BE/44/22/PL

Holy Cross Church Chichester Road Bersted PO21 5AU

External alteration including introduction of a new accessible ramp and steps to the main entrance, new external light and alteration of the existing paths. This application may affect the setting of a listed building and is in CIL Zone 4 (Zero Rated) as other development.

Martyn White
Principal Conservation Officer,
Planning Services

Drawing Title:  
**As Proposed  
Elevations**

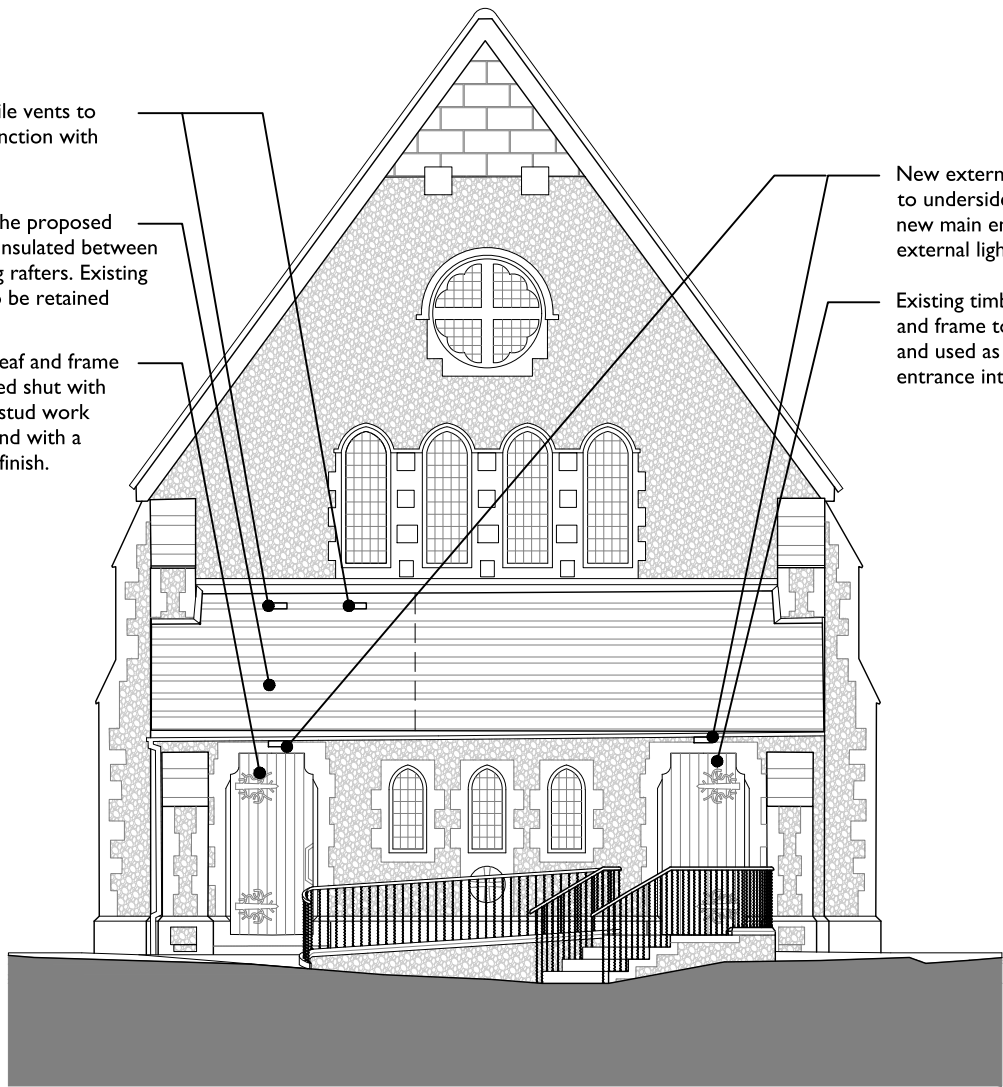
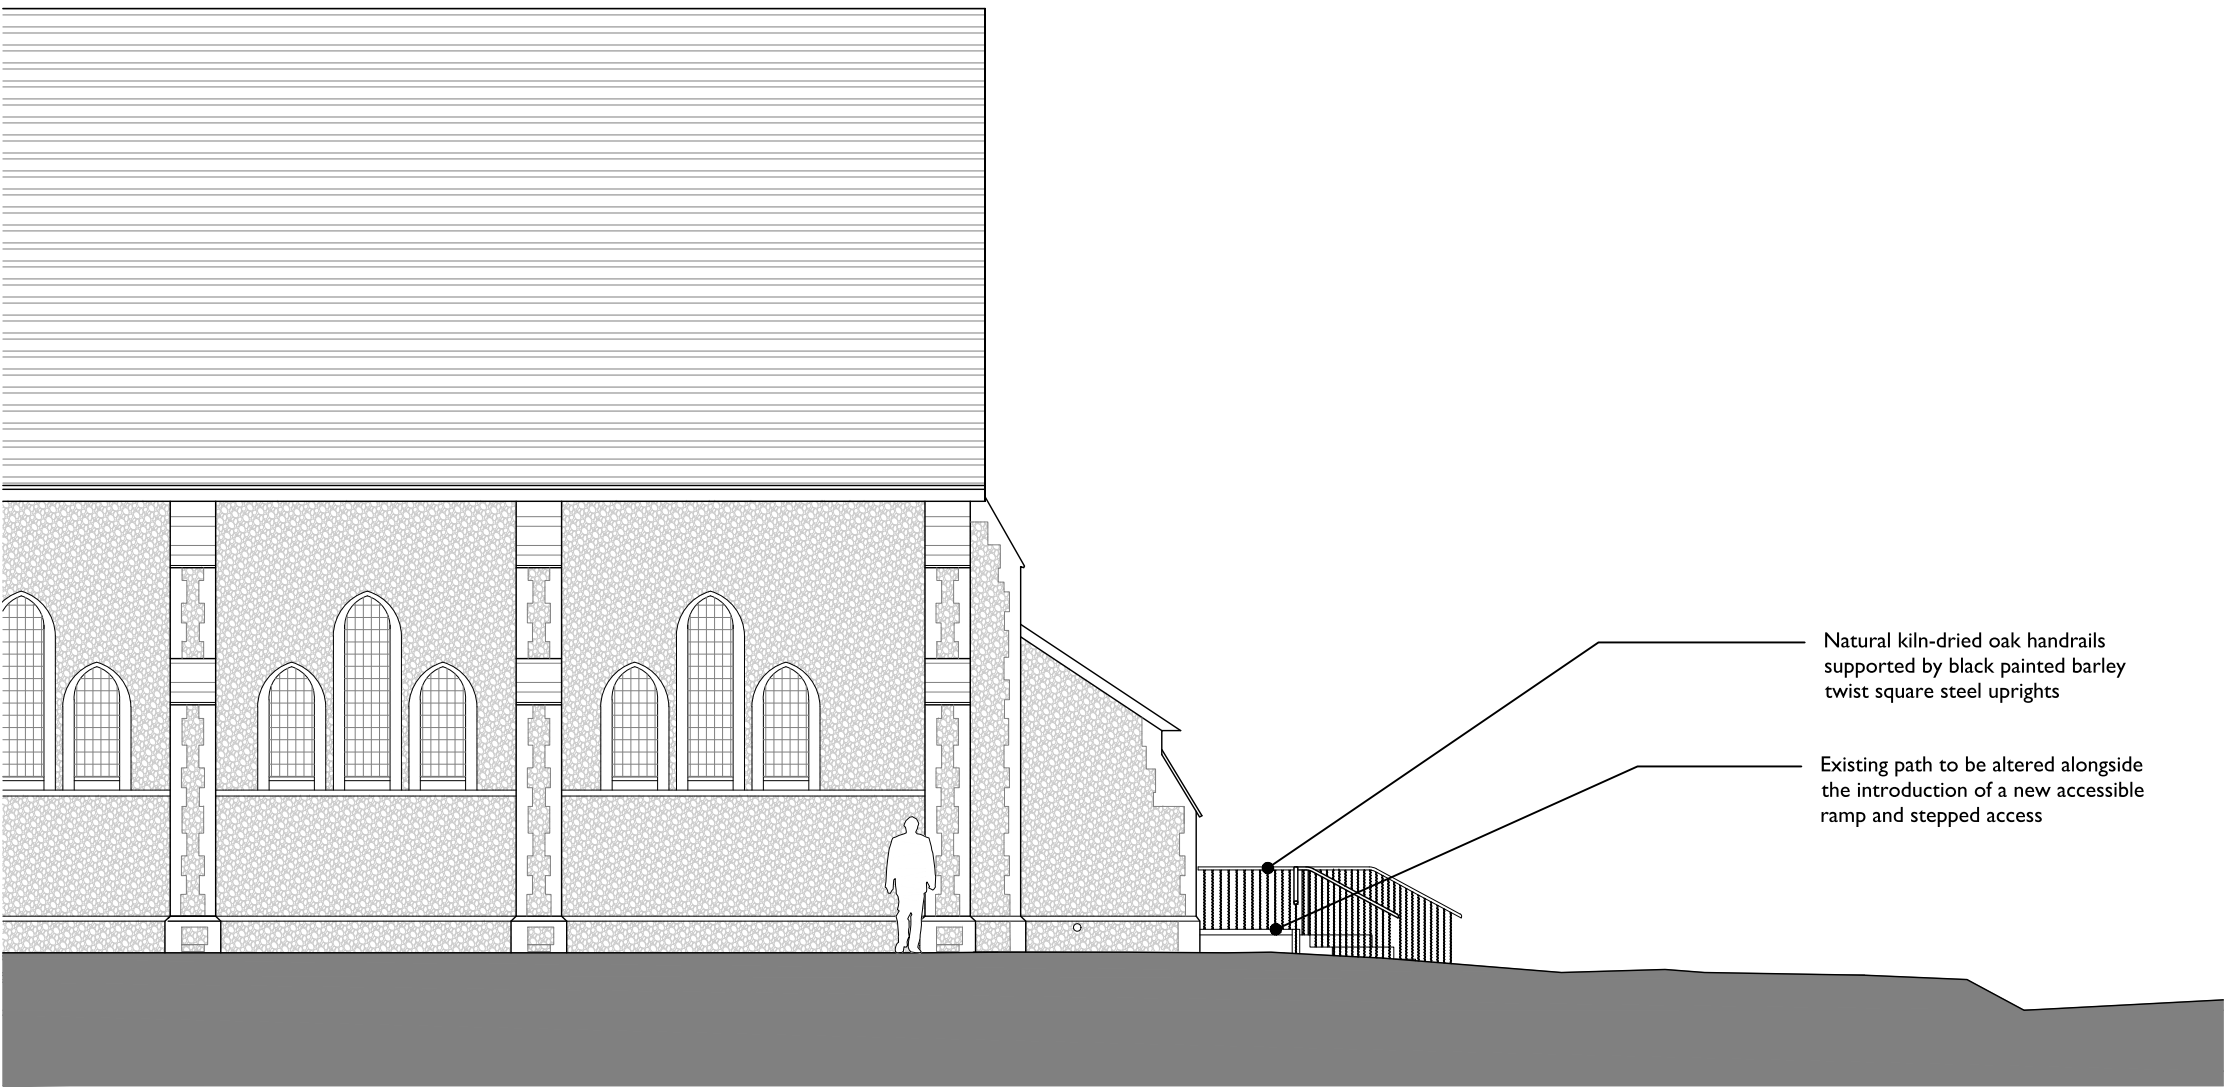
Whilst the church hall features external steps and ramp access, the same cannot be said of the church itself. The proposed design is small in scale and the materials have been chosen to reflect the existing structure – it is positive to note that flint will be used and that the existing blue brick pavers re-used. The success of the design will ultimately be dependent upon the quality of the materials used and the quality of the flintwork.
